Re: Defect Guarantee for 13-15 Bryant Street
Escrow Account #710-0000-229-40-14

SUBJECT: Request for Release of Defect Guarantee
11 Bryant Street - Duplex
(ID# 2005-0183) (Lead CBL#0129 C 003)

Philip DiPierro - Re: Bryant St./Four Sills

Site Plan
 11 Bryant Street
 Portland, ME

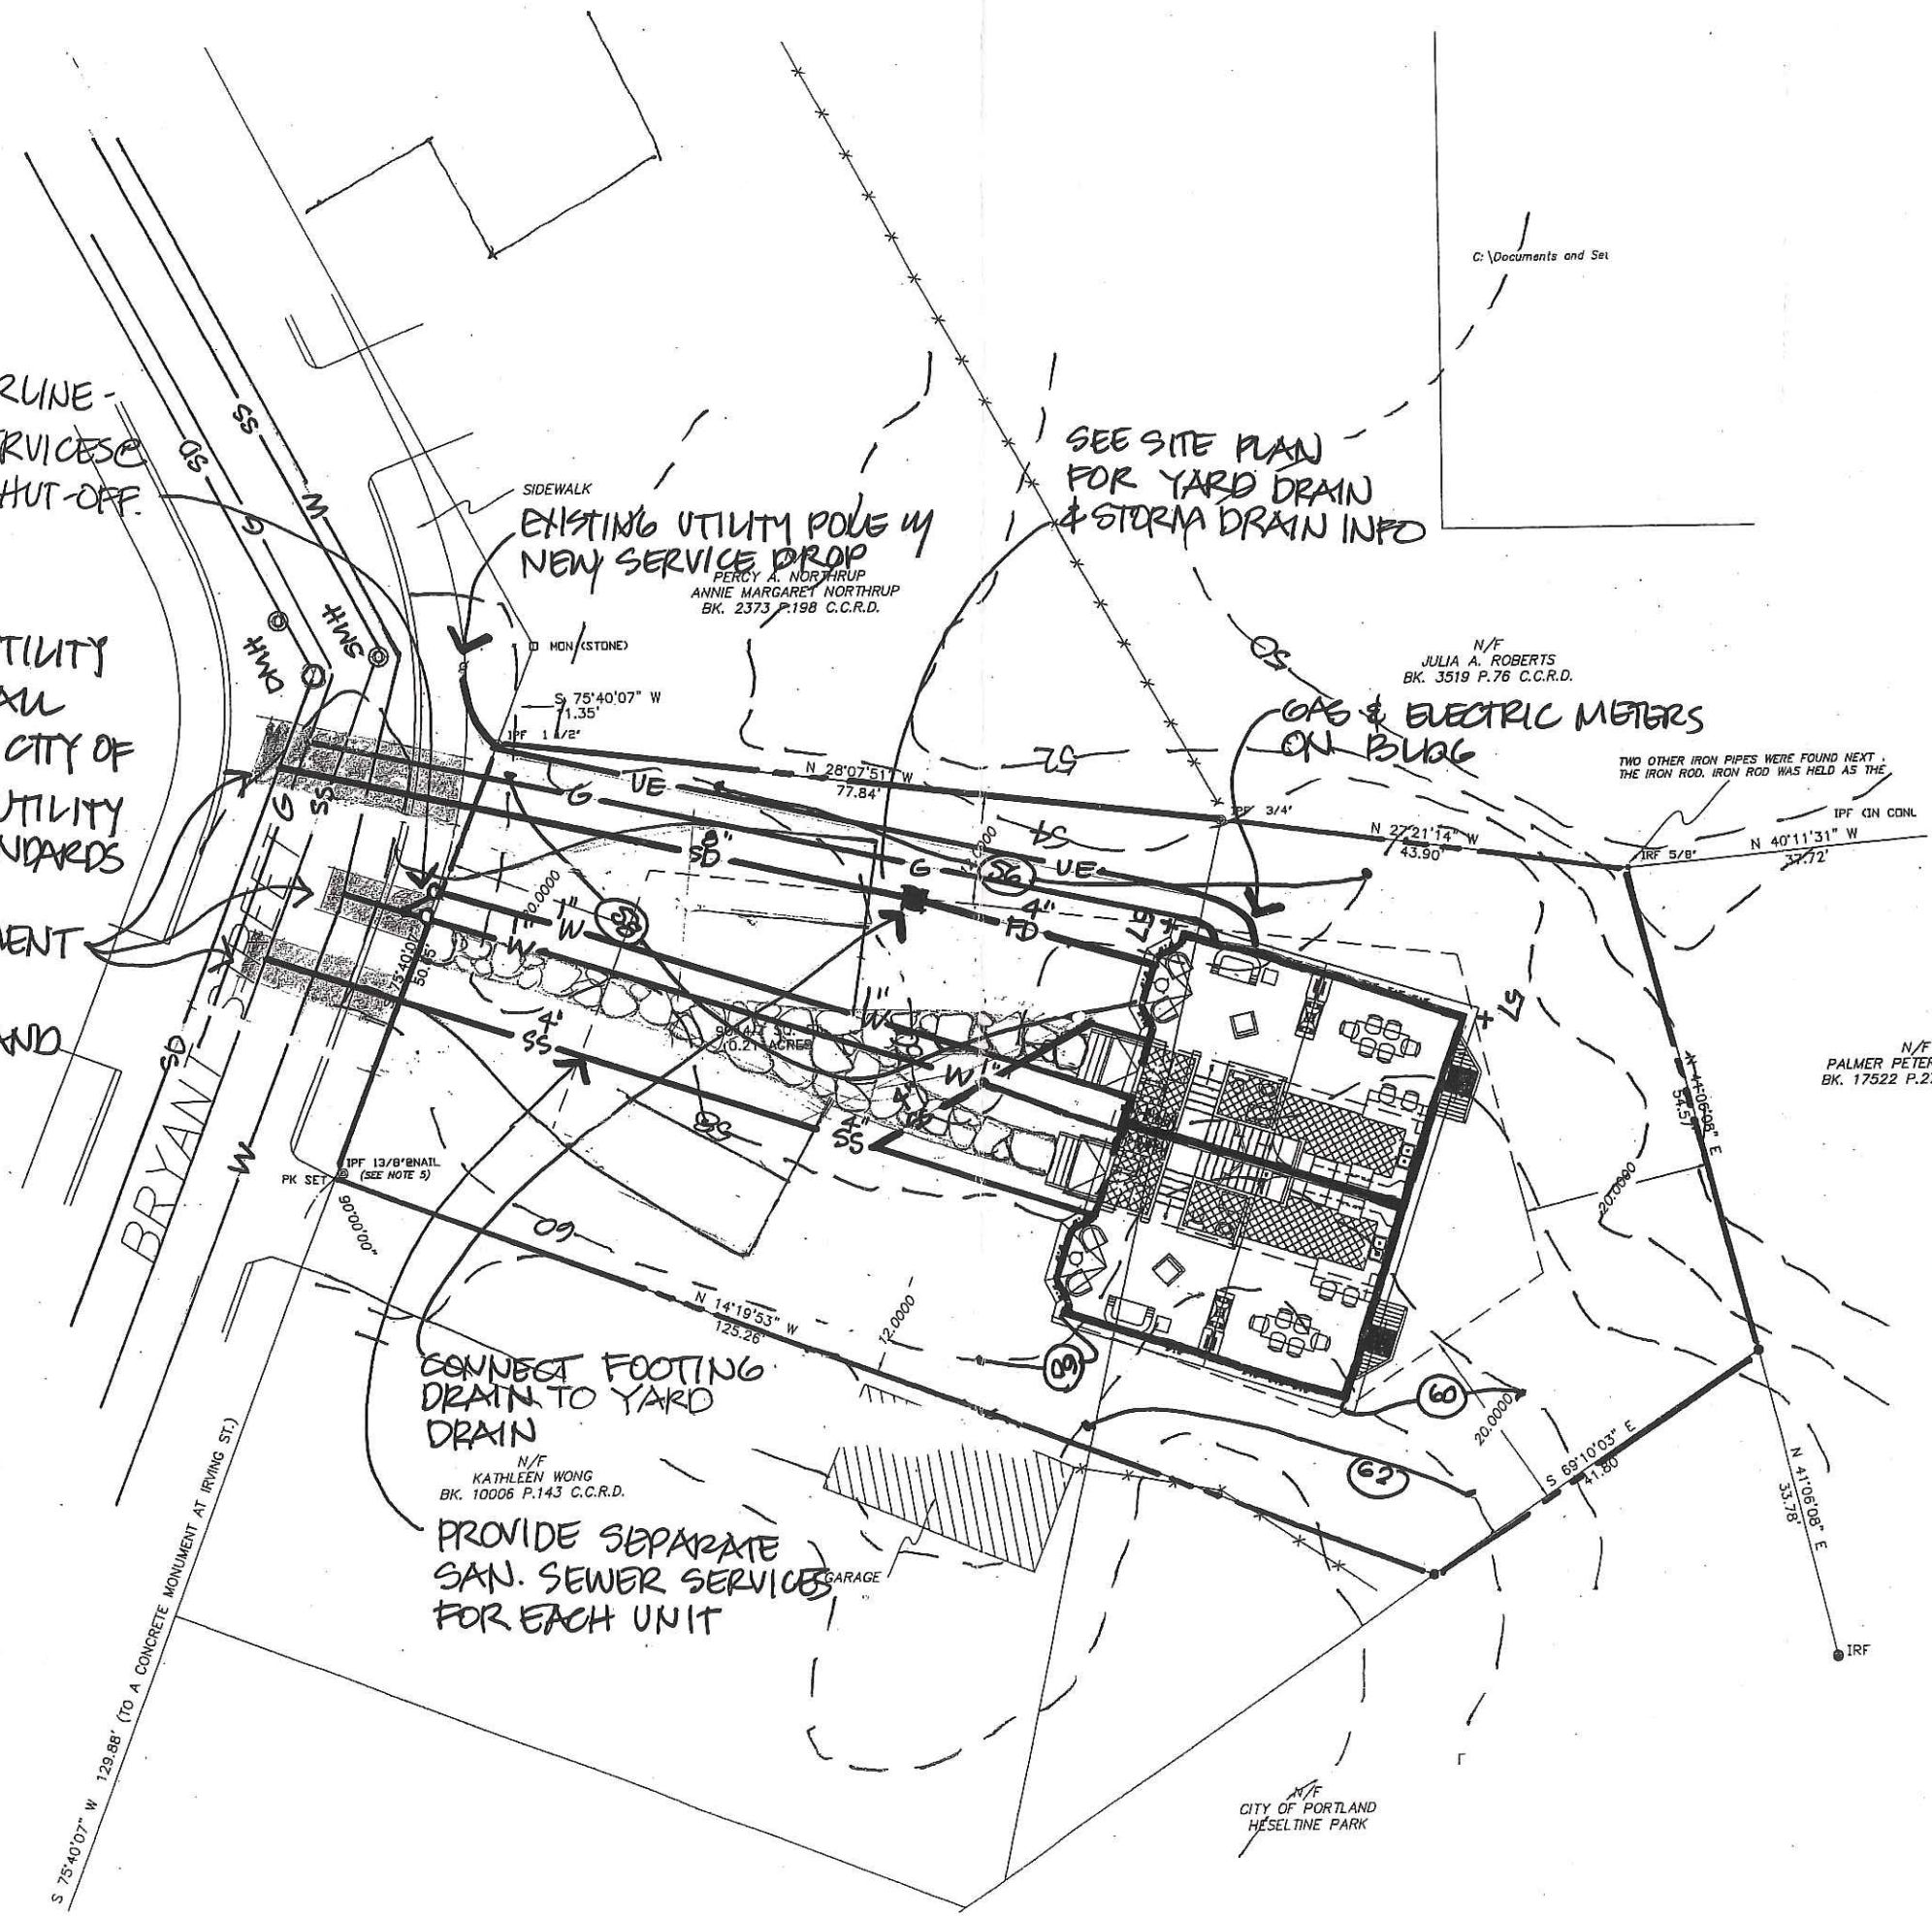
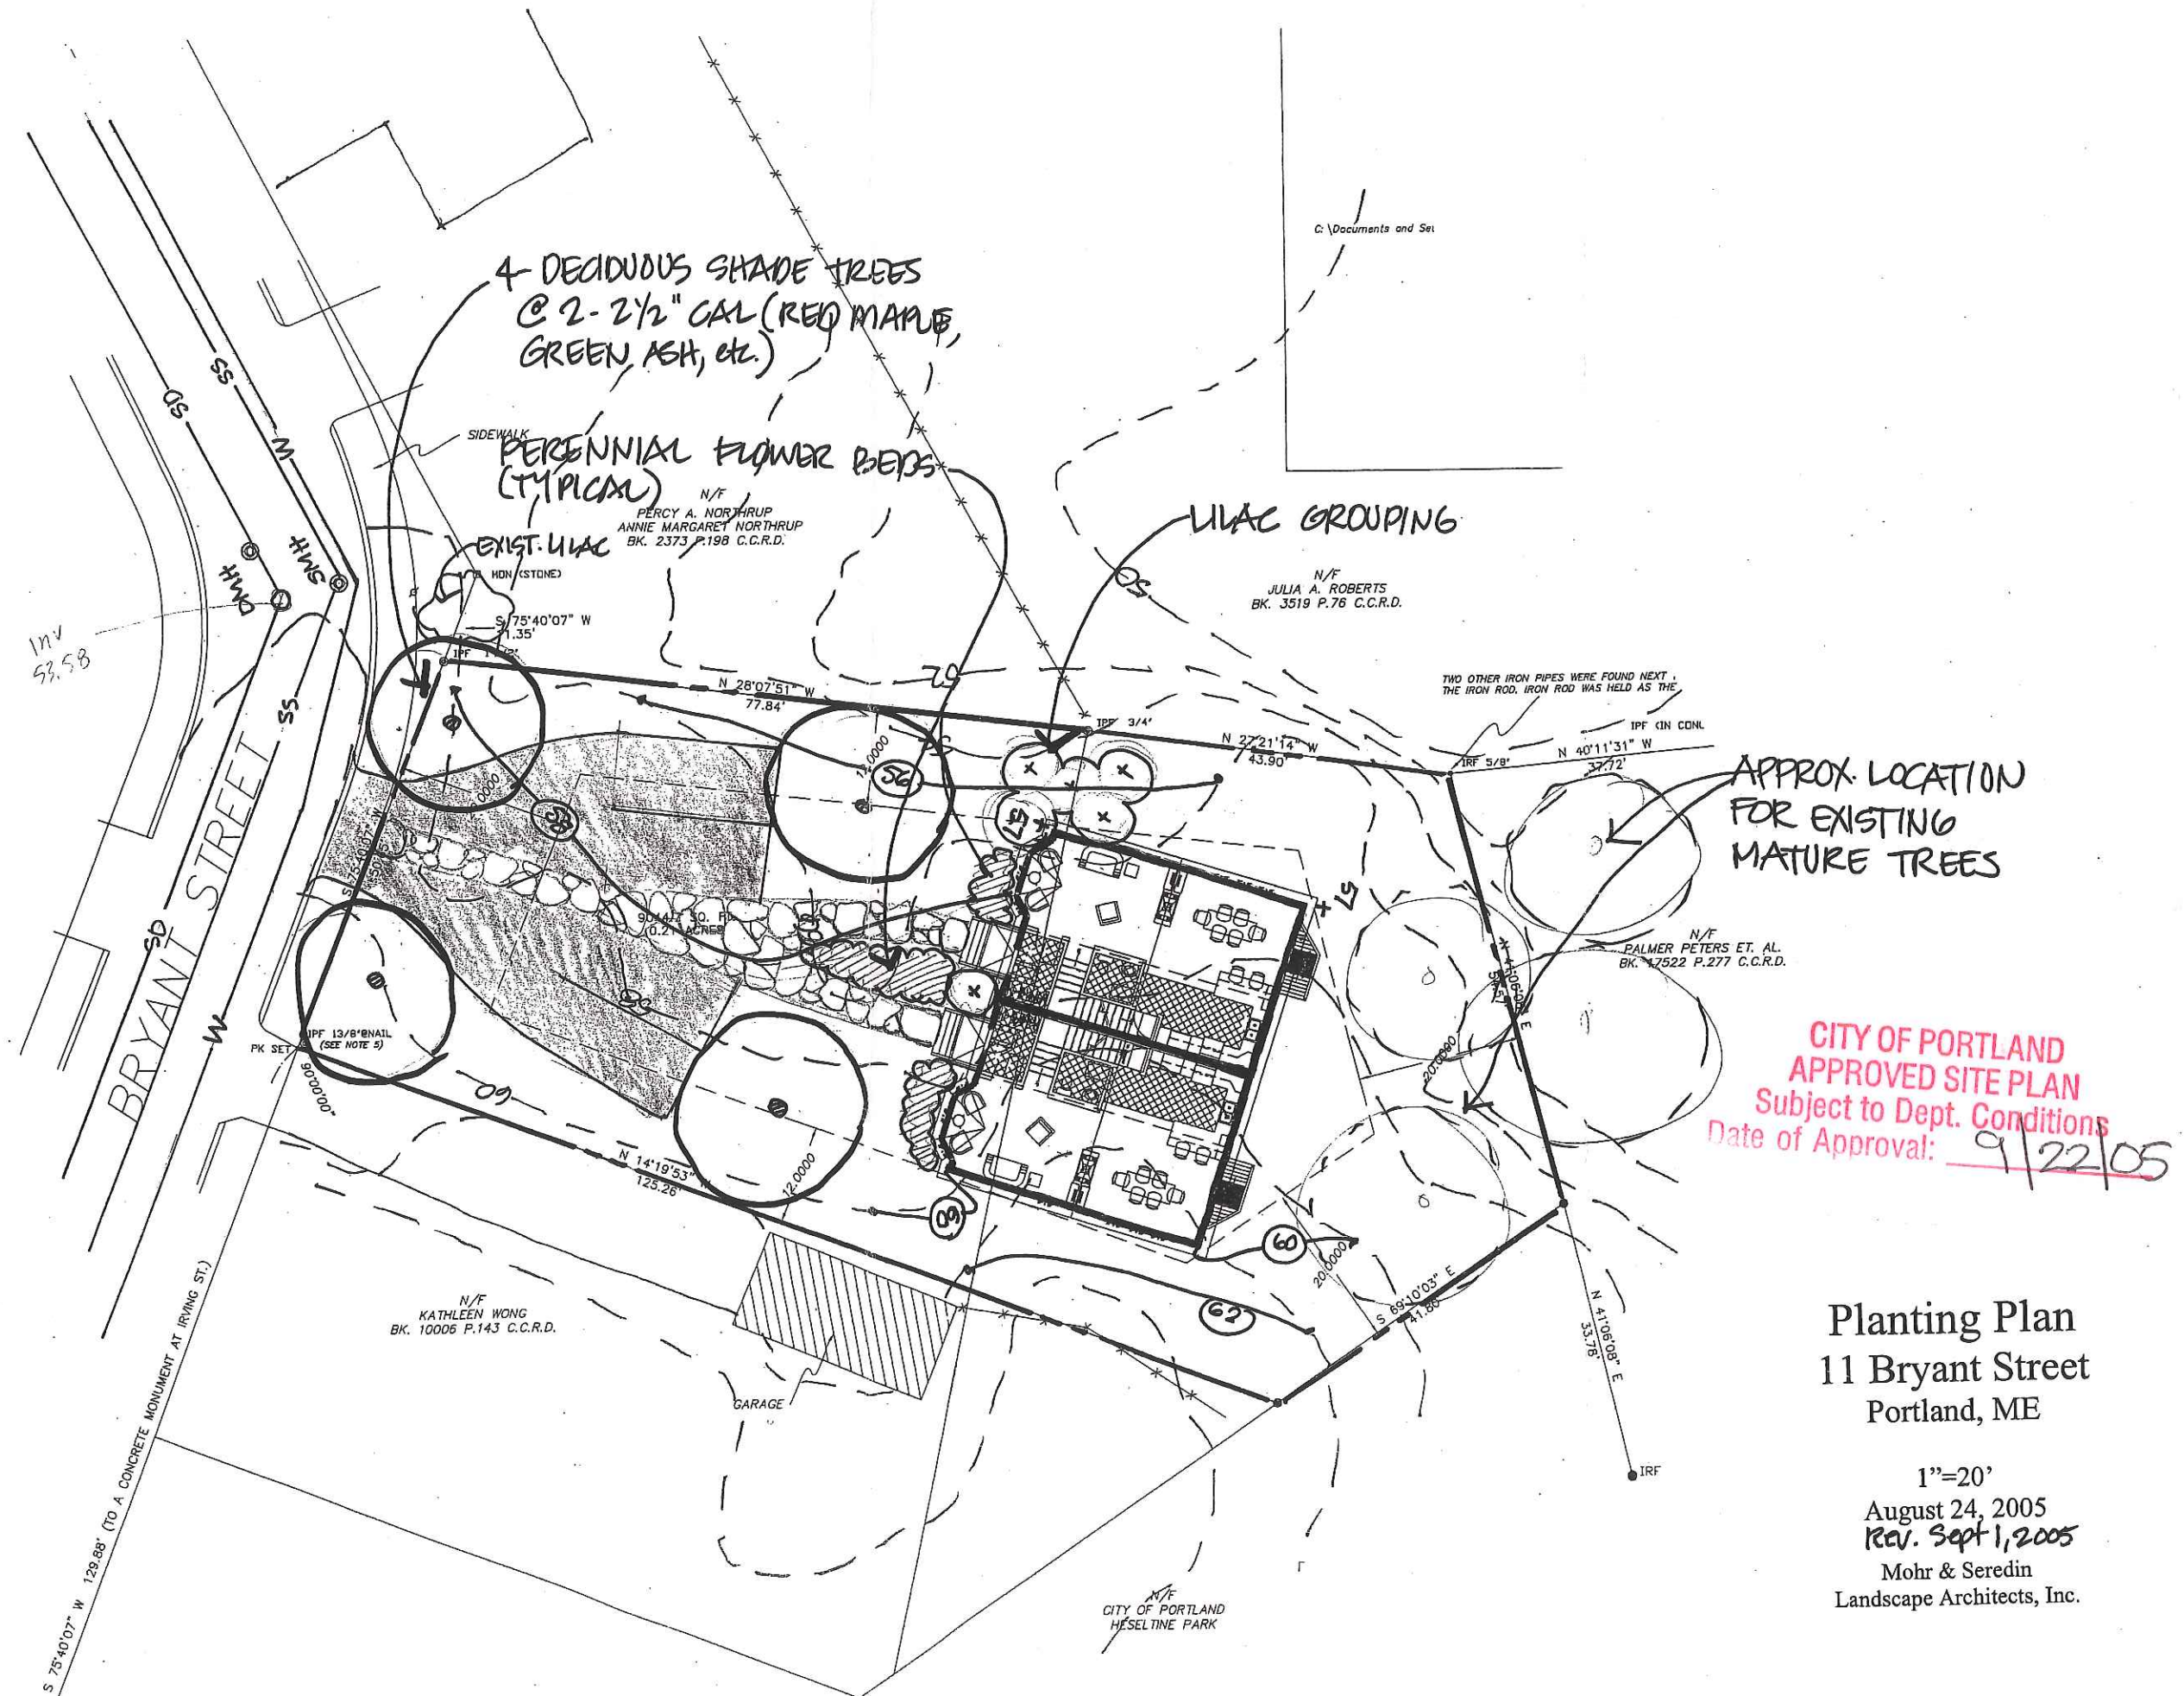
Recently I re-inspected the property you developed on Bryant Street to ensure that my drainage concerns were adequately addressed. It appears that a drywell was constructed in place of the "concrete catch basin with iron grate" that was shown on the approved site plan. I was not able to locate an amended plan, assuming one was submitted and approved, nor was I able to locate any notes that documented the change. I'm assuming this was an acceptable field change.

Your point that several inspections took place during construction and that your performance guarantee was reduced to the defect guarantee, is well taken. Ordinarily the developer would be required to construct the site according to the approved site plan (in this case installing the catch basin), but since no drainage complaints have been received by either the neighbor or the new property owners', and since the drywell performs essentially the same function as the catch basin, I can now release your defect guarantee. I will process your release request immediately.

FIELD INLET
N.T.S.

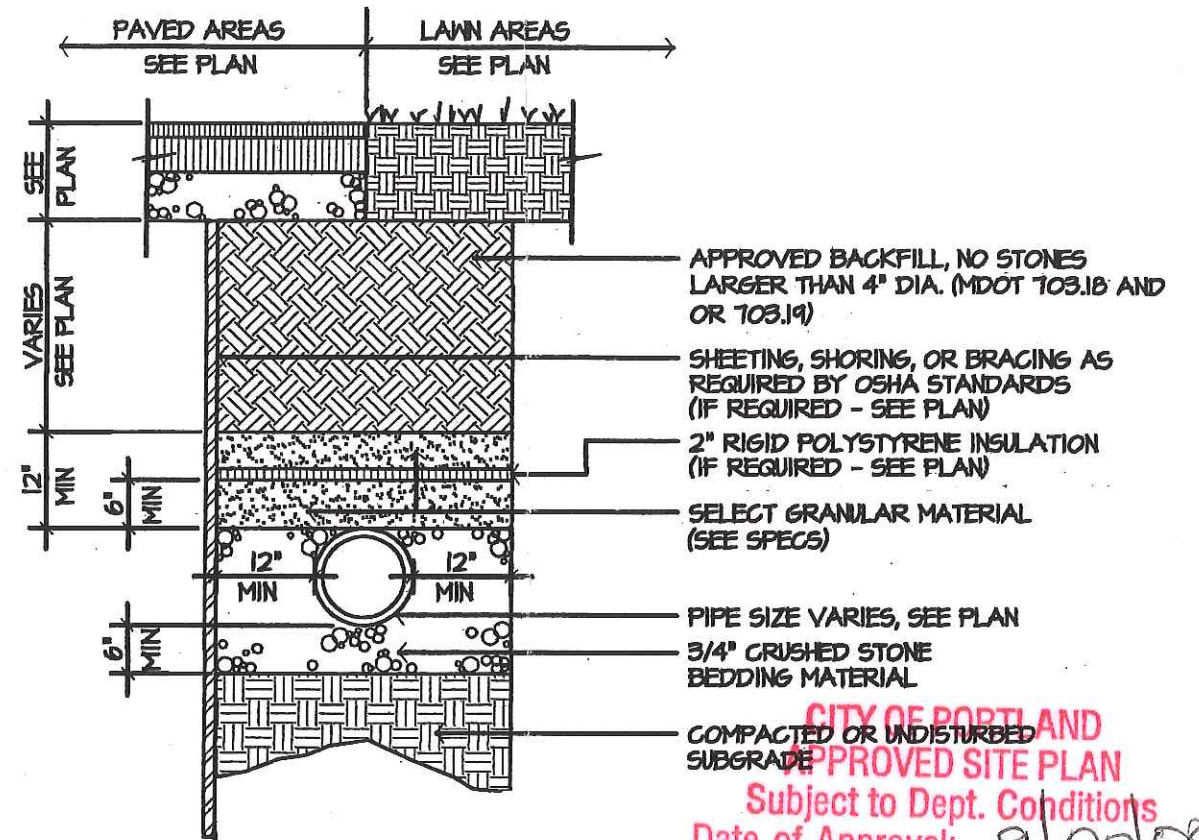
When I spoke to you about refunding the now expired bond, you went out to look at the property and then called to ask me where the pre-cast concrete yard drain was. I told you it was exactly where it is shown on the plan. You then said you needed to see it. I can't imagine why. Once it had been inspected, we were told by the city inspector that it could be covered

with sod after building up the sides with rocks and laying landscape fabric over the top. This was done in exactly the manner the inspector described. Why would our bond have been reduced if we had failed to follow the plans we submitted? When we last spoke you indicated that you had no records of inspections in the file. That seems incredible.
